RE: BL-18-00008 Clark

Community Development Services is in receipt of the above referenced application. The application has been deemed complete and **preliminary approval** is hereby granted. Pursuant to Kittitas County Subdivision Code Chapter 16, please note the following items must be completed prior to final approval of the boundary line adjustment and must be submitted to our offices for review:

TO: Community Development Services
FROM: Taylor Gustafson, Environmental/Transportation Planner
DATE: June 18, 2018
SUBJECT: Clark BL-18-00008

CLARK PROPERTY

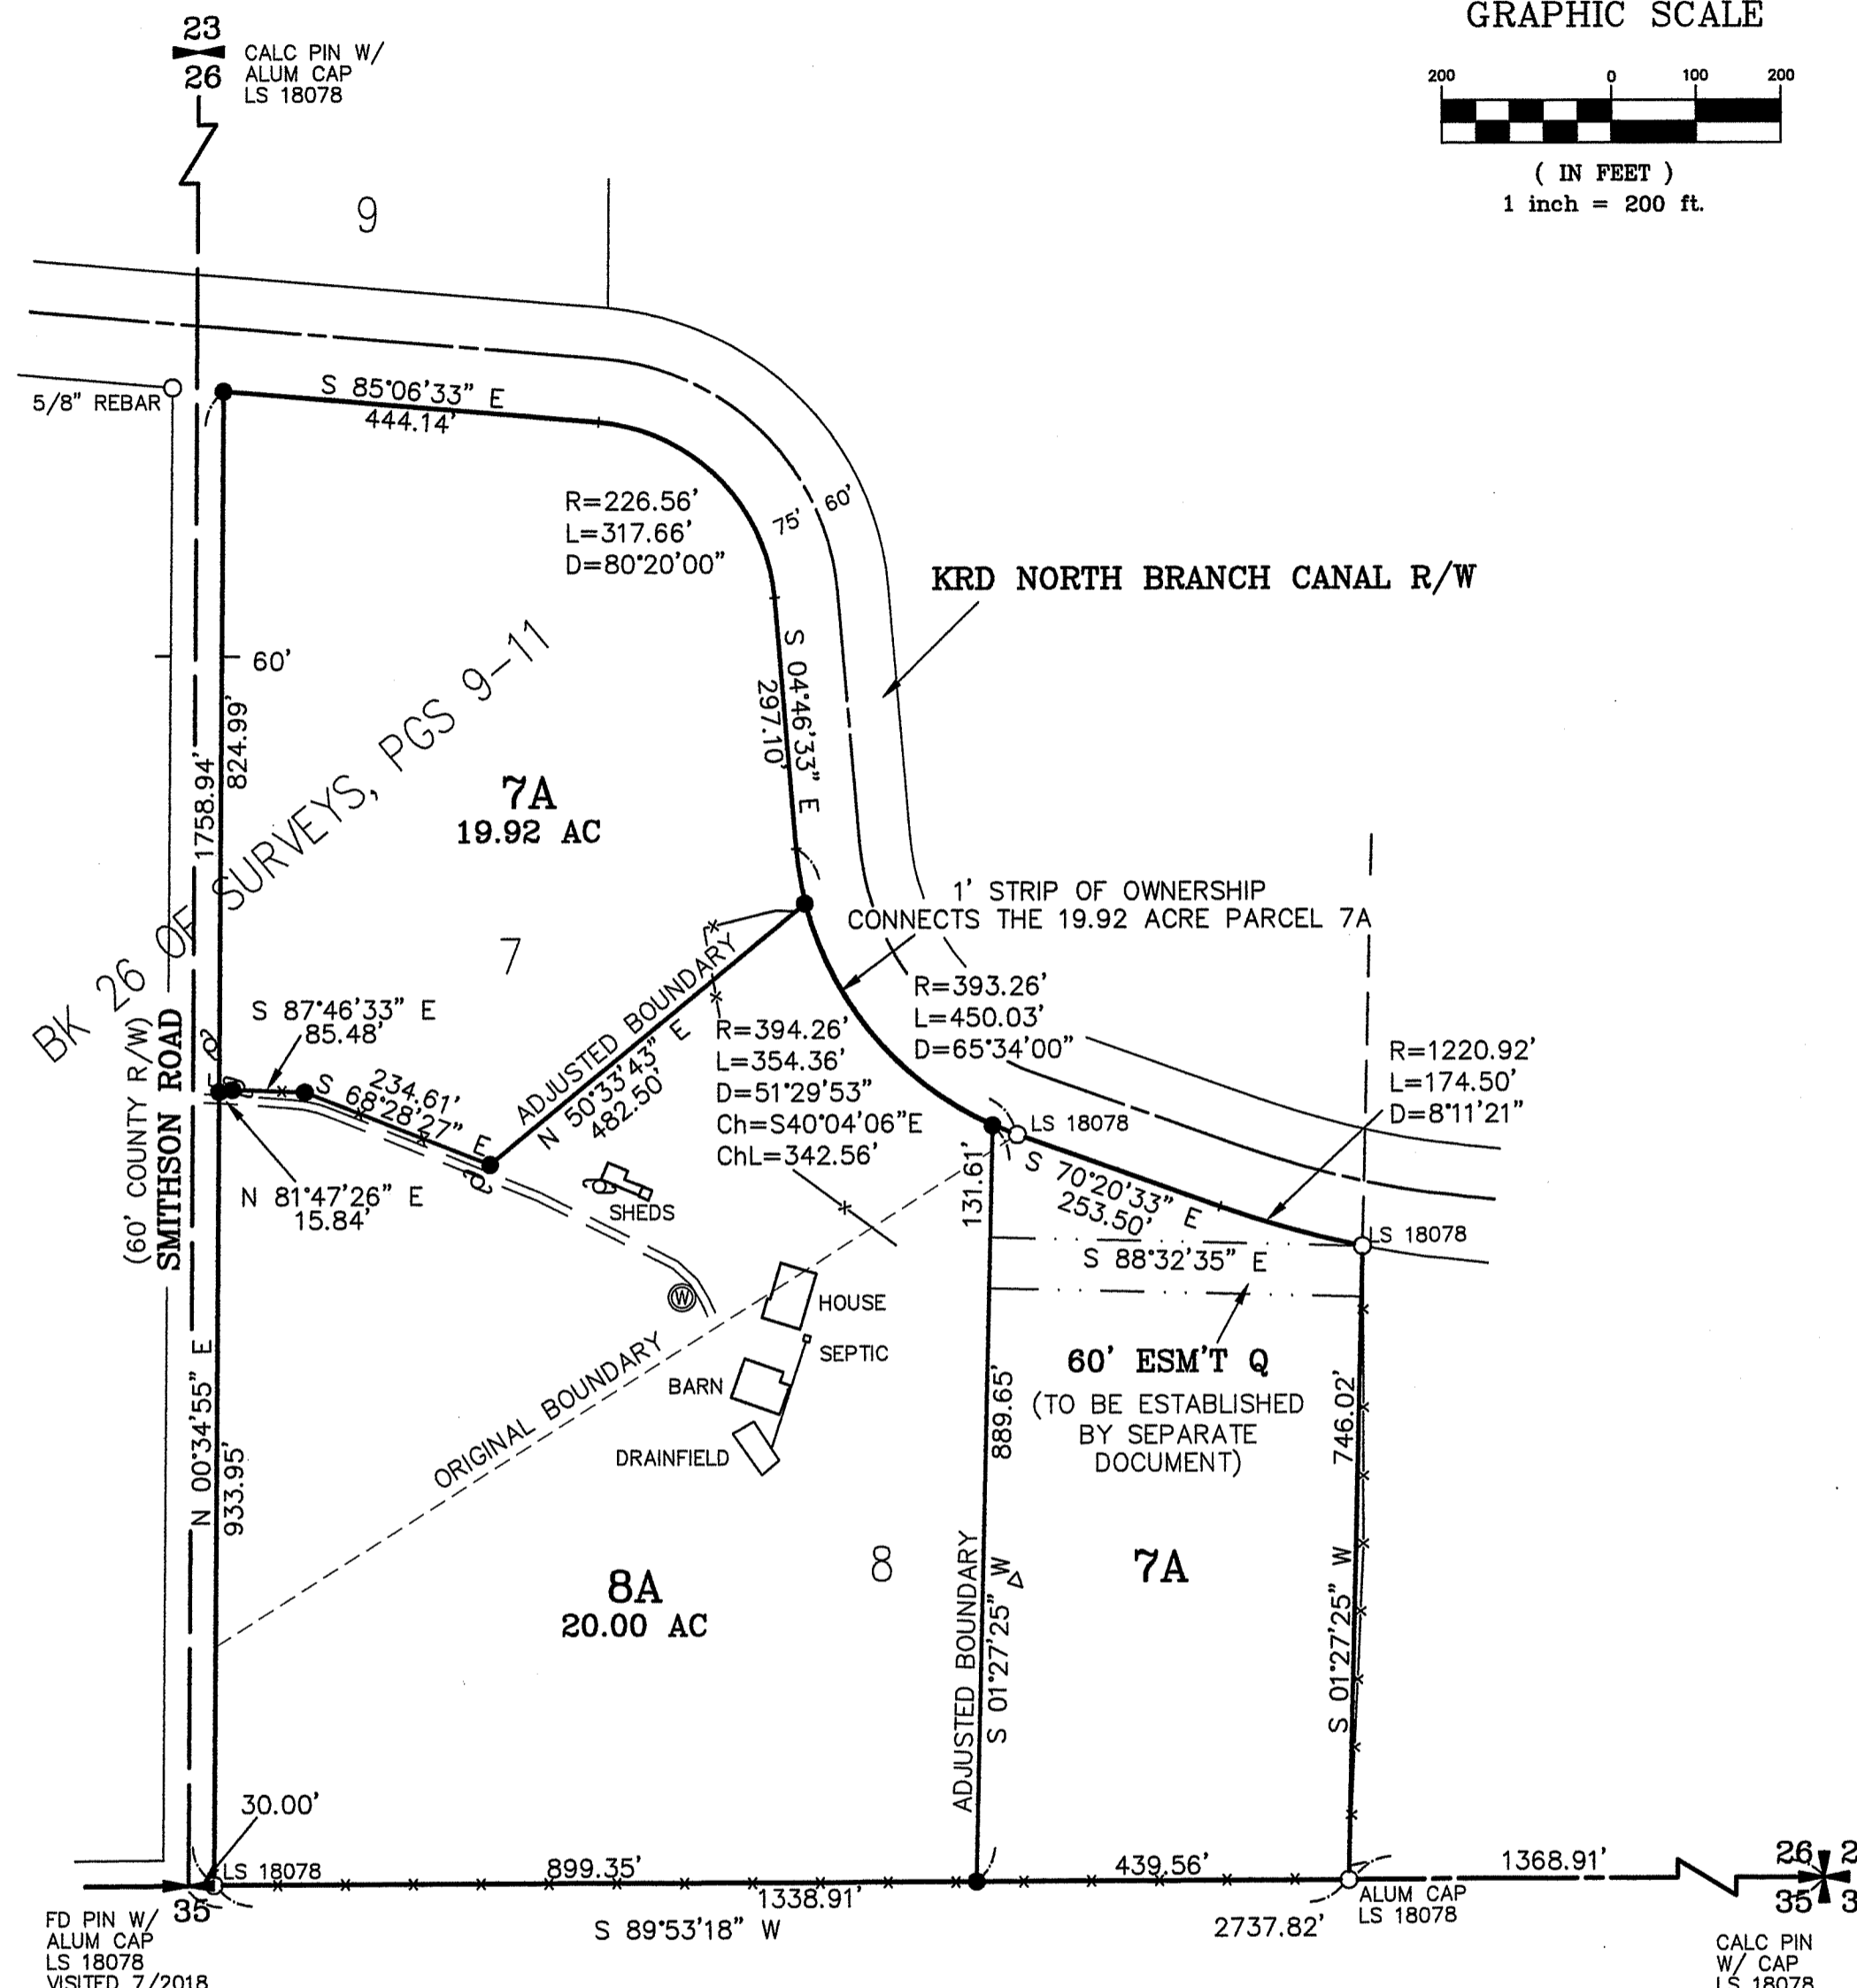
Dusty – There is access to the buildable portion of Lot 2 that fronts Smithson road. It was our intent to not allow access to the back half of lot 2 as the previously owner discussed with KCCDS before we submitted. Our layout meets all county code as I interpret it, can you please point out the code that requires us to provide access to the entire property.

1. Provide sufficient access to the back half of lot 2. Proposed map shows only a 1' strip of land connecting the two sections.
2. Map shows County Right of Way as Church Road. Please relabel to Smithson Road.

I have spoken with Mark in regards to the BLA and we will not require the applicant to address the access issue to the back half of the property.
